## ***Rezoning Petition Review***

**Rezoning Petition #:** 20-133

**Location of Property:** Approximately 26.20 acres located on the south side of Hamilton Rd, east of Youngblood Rd and west of Steele Creek Rd.

Conceptual Site Plan

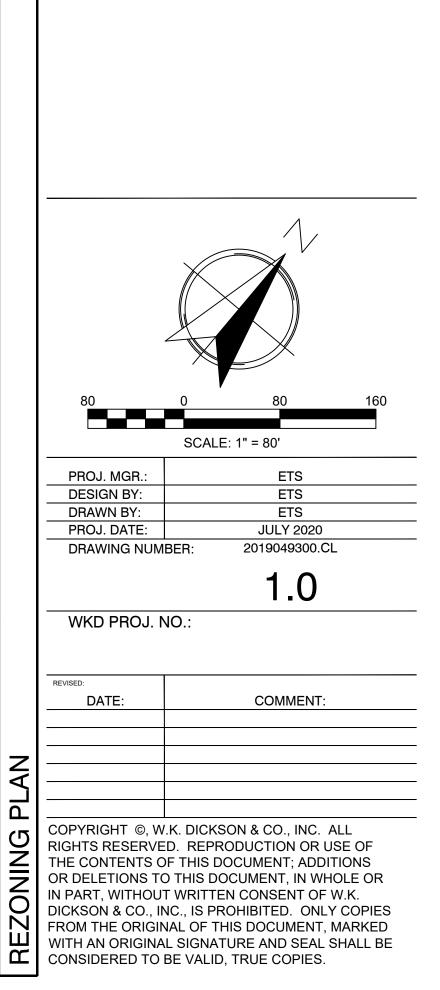
**Concerning Storm Water:** Please include the following note under Environmental Features. *For adjoining parcels receiving storm water discharge the petitioner shall analyze the adequacy of the existing storm water conveyance on the adjoining parcels to and including the nearest public R/W. If the existing storm water conveyance on the adjoining parcels is found to be inadequate, the Petitioner shall make a good faith effort with the property owner(s) to improve the storm water conveyance or mitigate the storm water discharge onto the adjoining parcels.*
